RE:- Manor Nursery Site High Street Angmering

Thank you for your correspondence of 1st October 2018, advising me of a revised layout plan for reserved matters application A/38/18/RES, for which you seek advice from a crime prevention viewpoint.

I have had the opportunity to examine the detail within the application and make the following comments regarding the changes indicated on ECE Architecture's drawing no 100 revision 7, dated 01.03.18.

CAD Plot date: 1/10/2018 - 12:11:48 6345 site layout.dwg

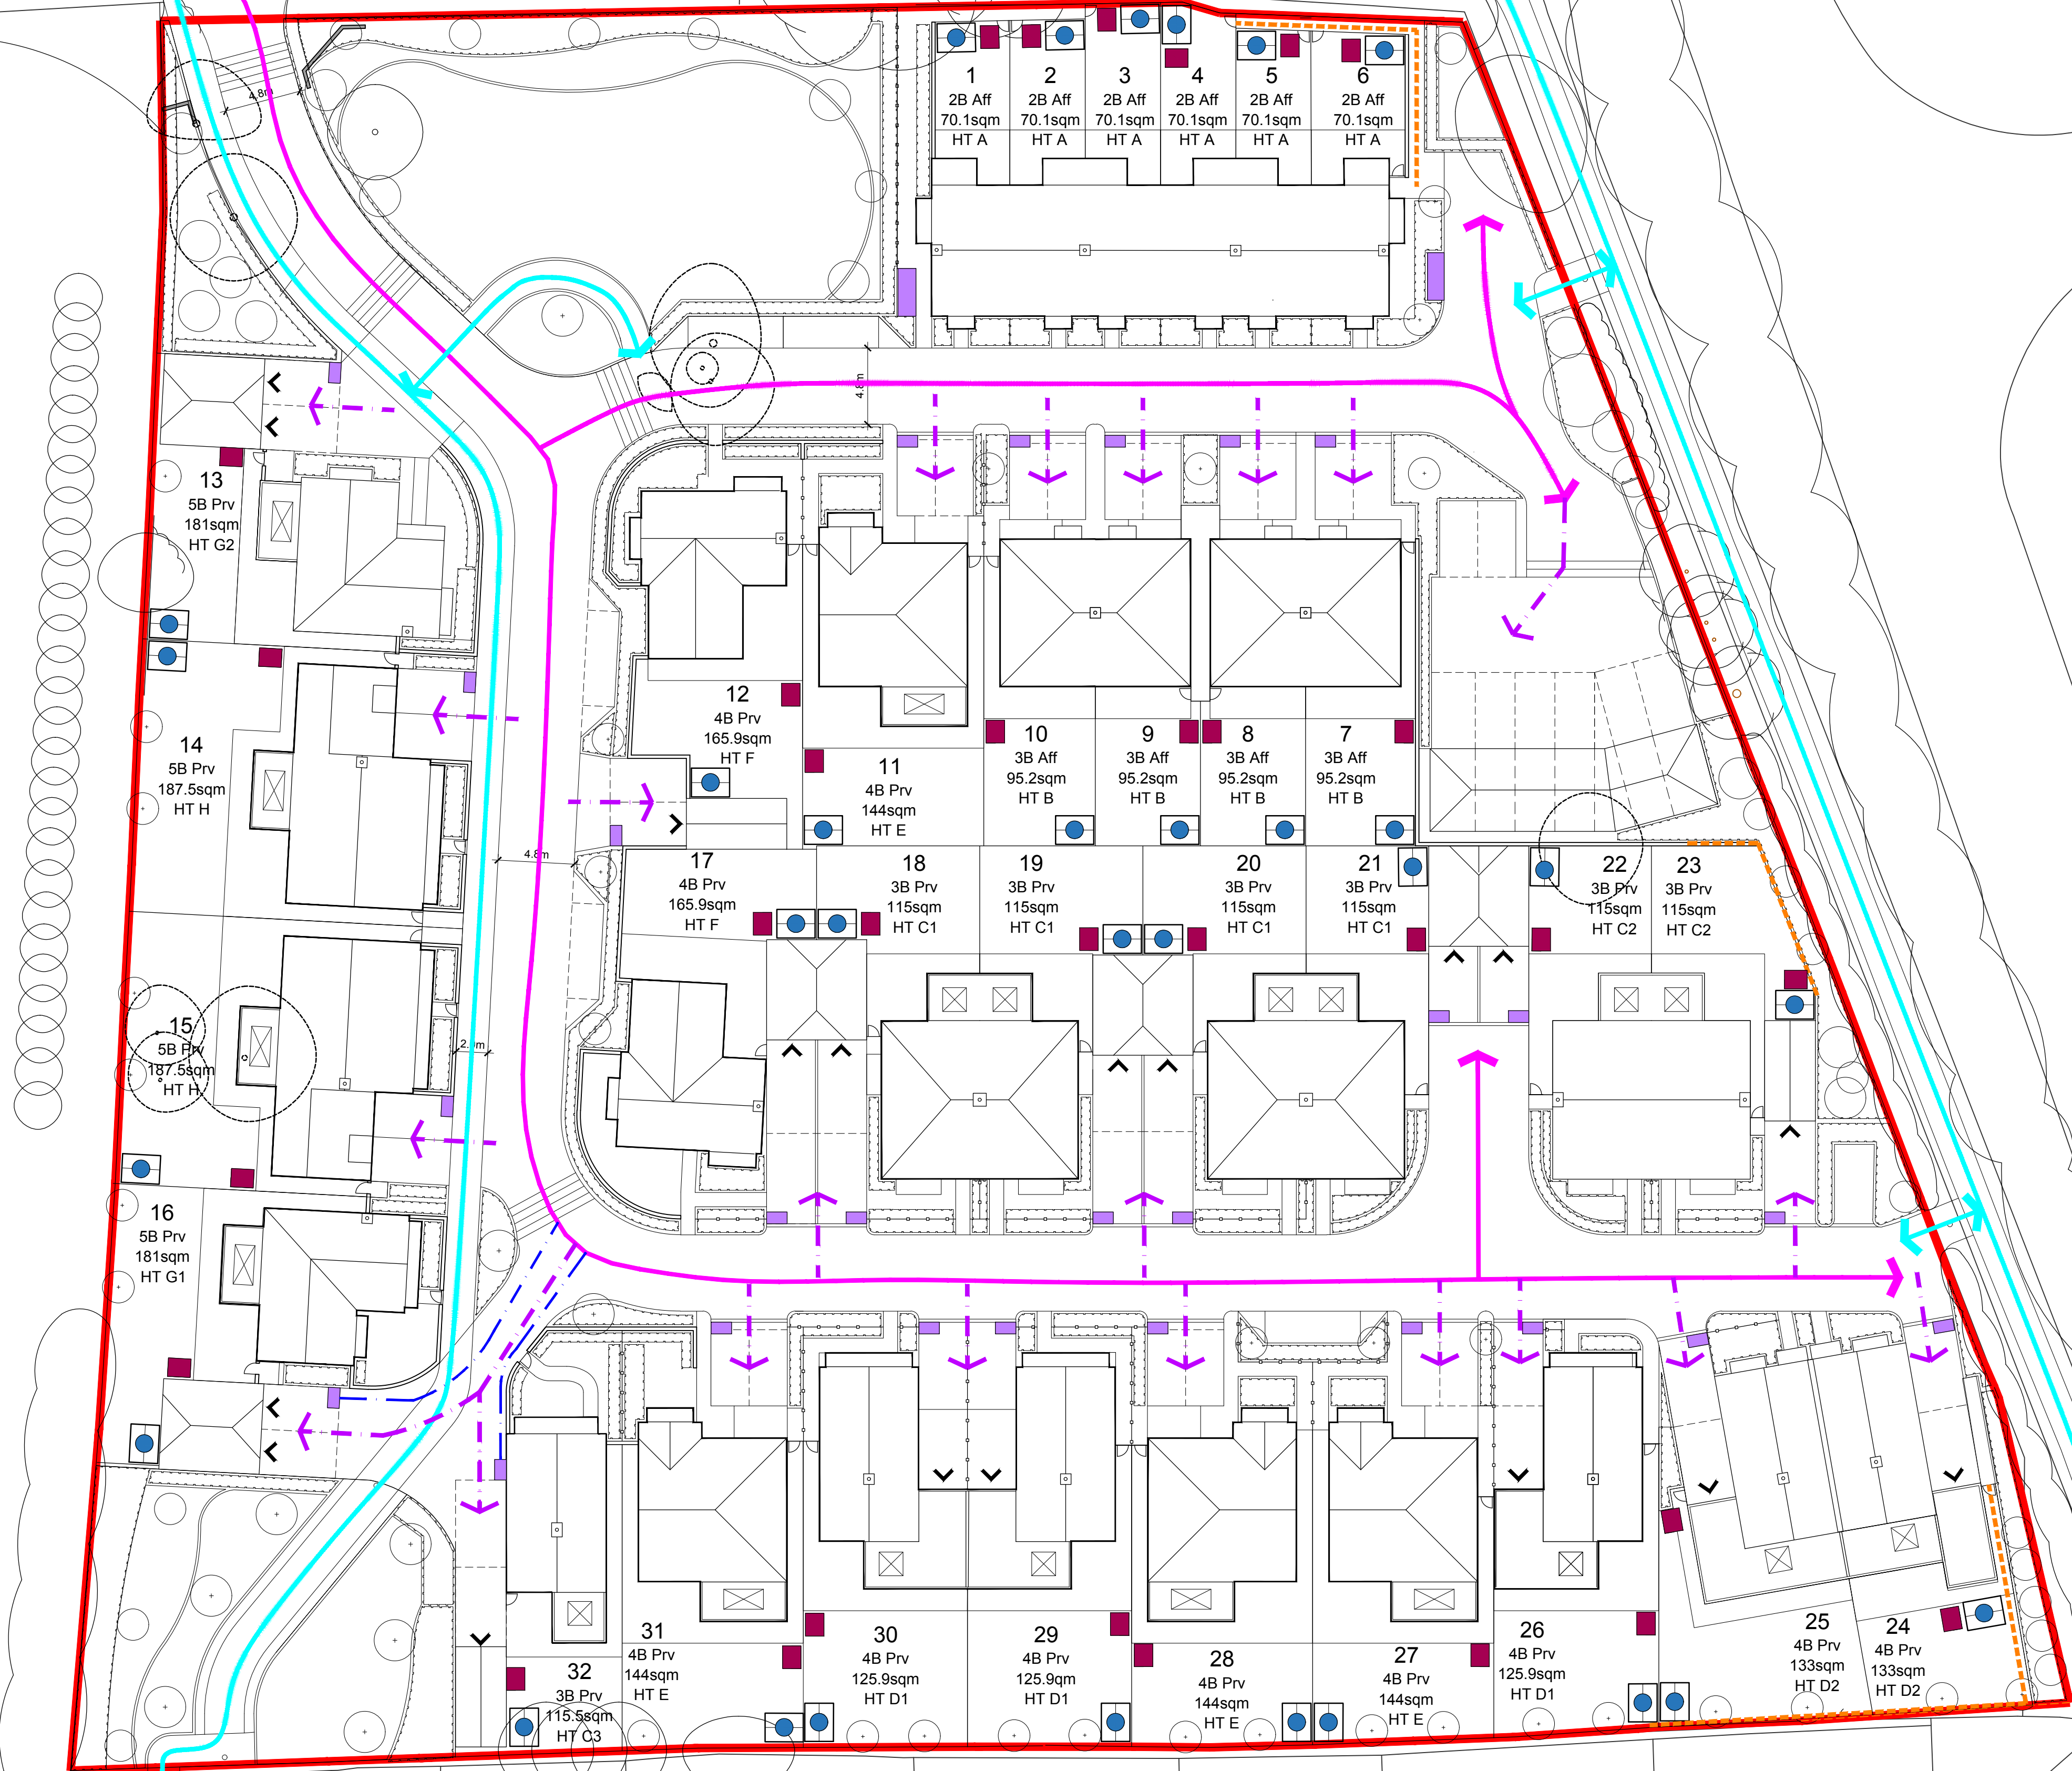
In regard to the wider path at the south west corner of the plot I would recommend controlled access with bollards to deter vehicle access other than by emergency vehicles.

In relation to dwellings 1 to 6, I am pleased note bays have been added at either end of the terrace to aid passive surveillance. However they do not provide a physical obstruction to the rear pathways and would still allow unauthorised access to the back fences and gates during the hours of darkness when occupants of the properties are asleep.

In addition I still have concerns regarding those rear garden pathways at each end of the terrace that lead to dwellings 1, 2 and 3 from the west side and dwellings 4,5 and 6 from the east side. Within the rear gardens of dwellings 1 and 2, and 5 and 6, the positioning and height of the garden sheds against the back fence also reduces observation of the back paths from the dwellings, and would recommend the sheds are repositioned in the garden.

I am pleased to see that the garages to house No's 13 have been set further back to assist with visibility on the corner of the entrance road.

From a crime prevention viewpoint ,in circumstances that require a more open feature such as a garden overlooking a rear garden pathway, 1.5metre high close board fencing topped with 300mm of trellis can achieve both security and surveillance requirements. This solution provides surveillance into an otherwise unobserved area and a security height of 1.8 metres. Gates that provide access to the side of the dwelling or rear access to the gardens must be robustly constructed of timber, be the same height as the adjoining fence and be lockable from both sides. Such gates must be located on or as near to the front of the building line as possible.

The outer perimeter fence of the back garden path should be 1.8 metres in height.

Gravel pathways may assist in detecting persons using the above paths.
